REPORT UPDATE

Application No: AB/8/10/

Change of description- 'Erection of fencing to rear boundary.'

LOCATION: 11 Mount Pleasant
Arundel

INDICATIVE BLOCK PLAN

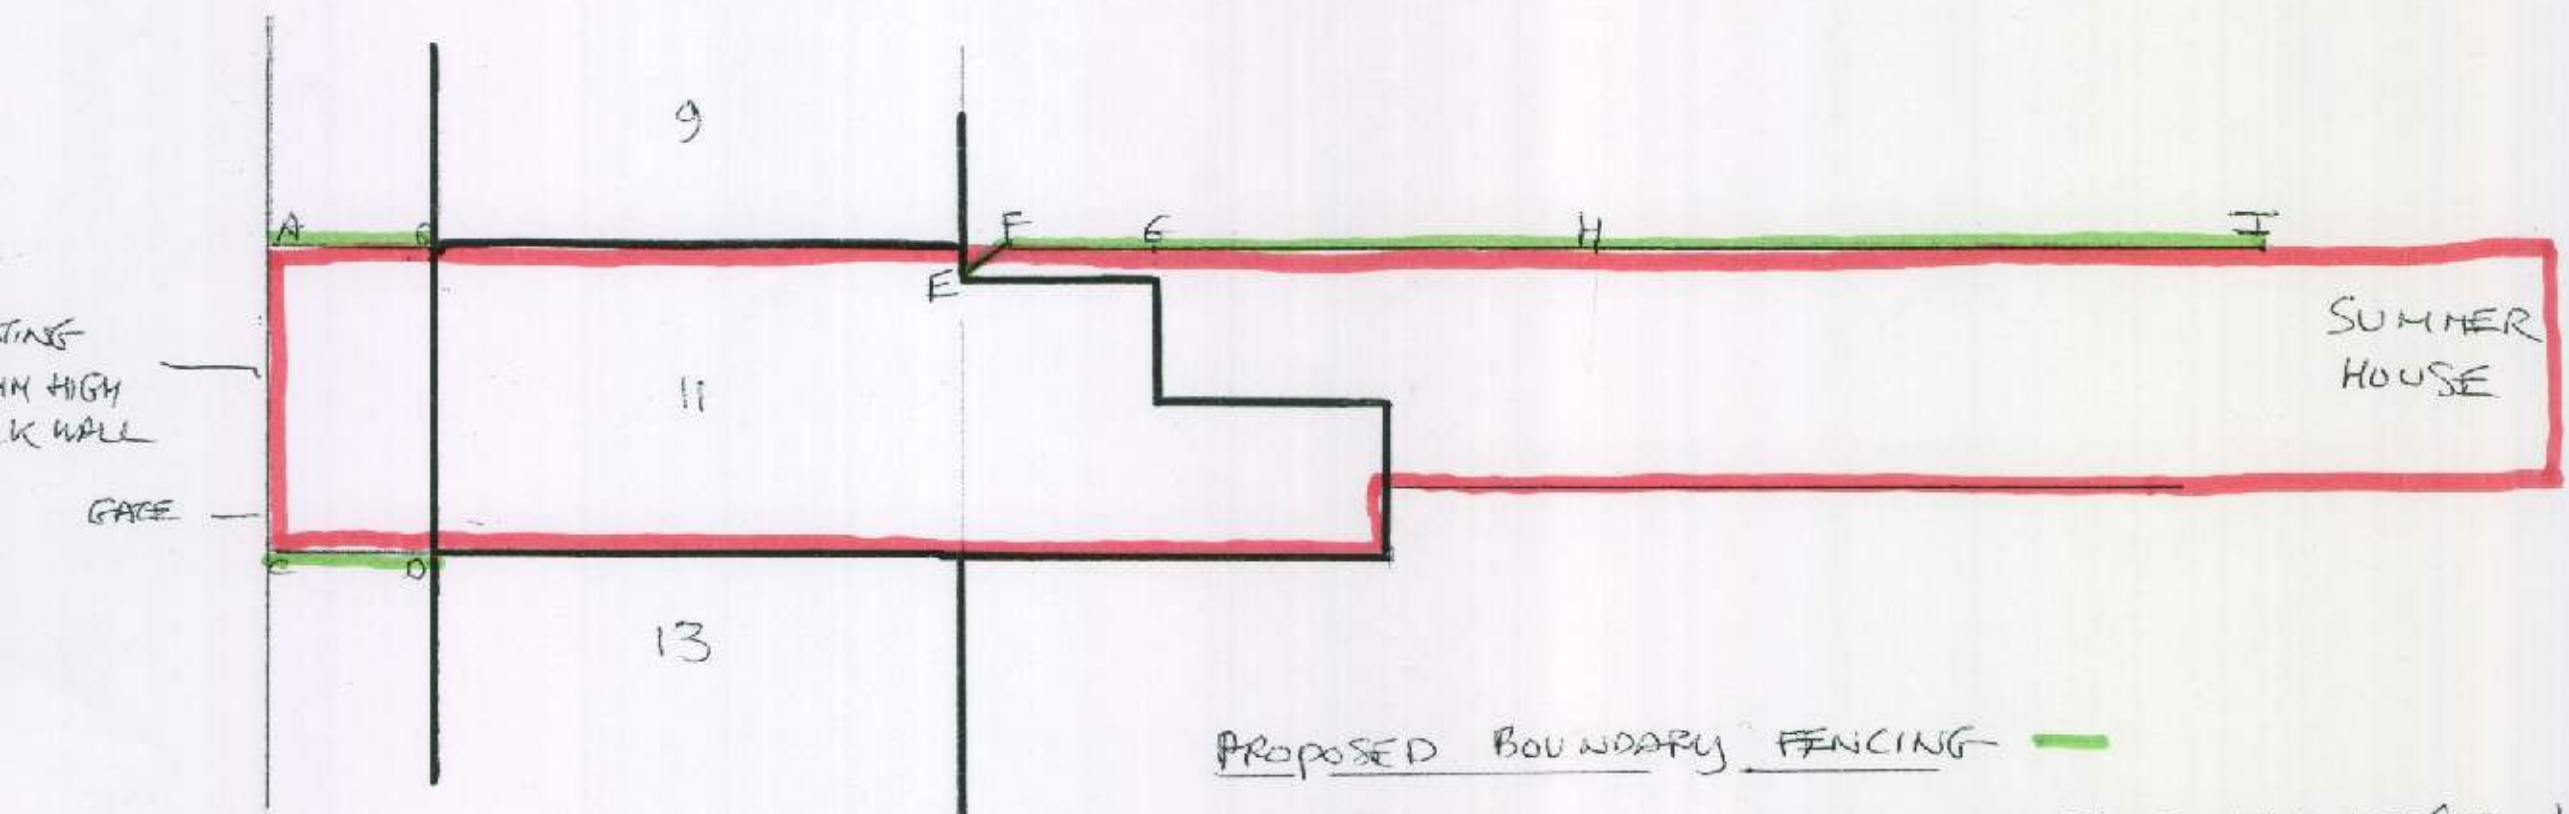
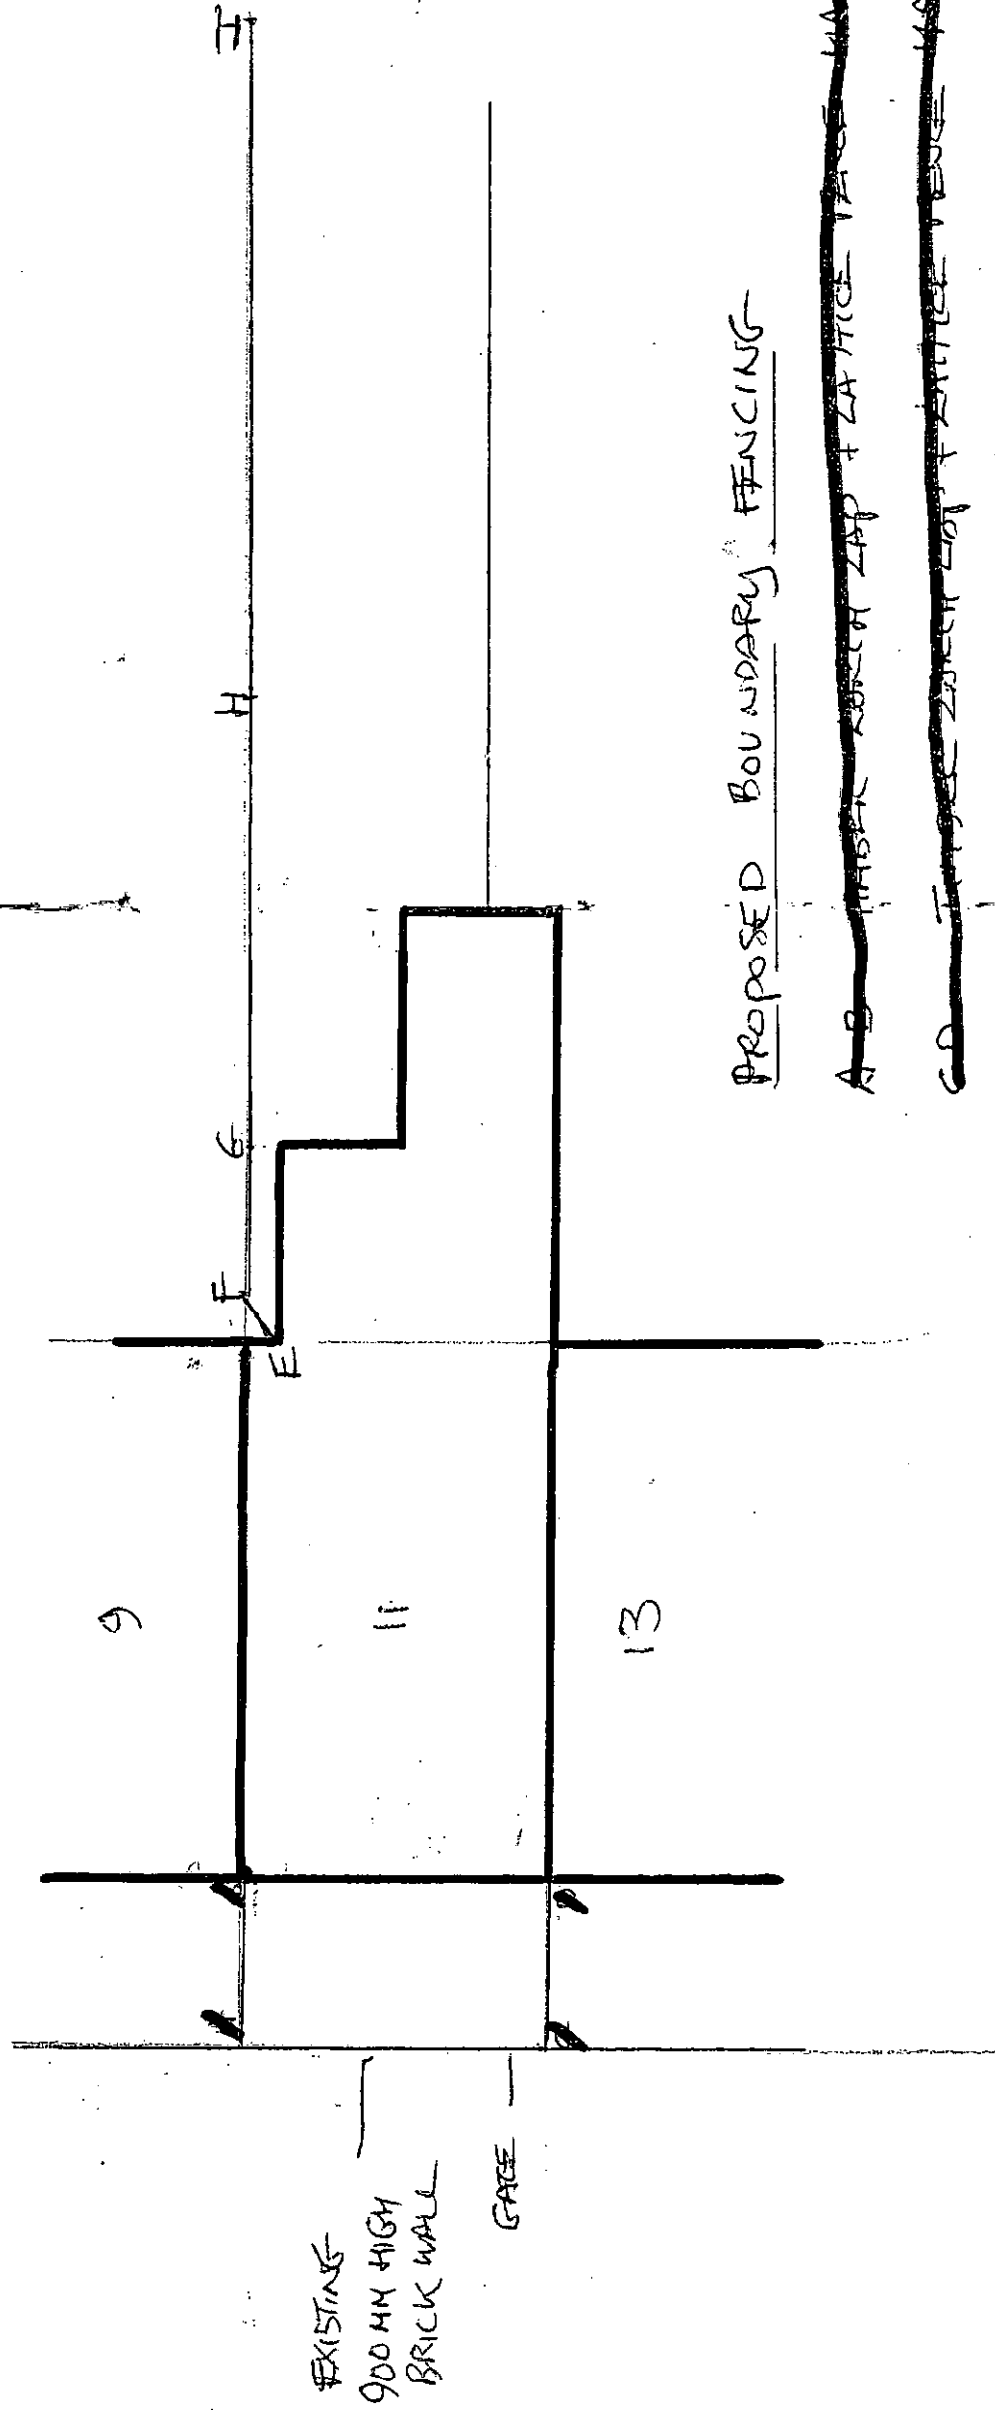
The fencing to the front boundaries no longer forms a part of the application. Amended conditions and substitute indicative block plan attached.

- 2 This permission relates to the following approved 1:1250 plan; 1:100 Block Plan (Substitution dated 25-3-2010) and Photo No. 3; 4; 5; and 6.
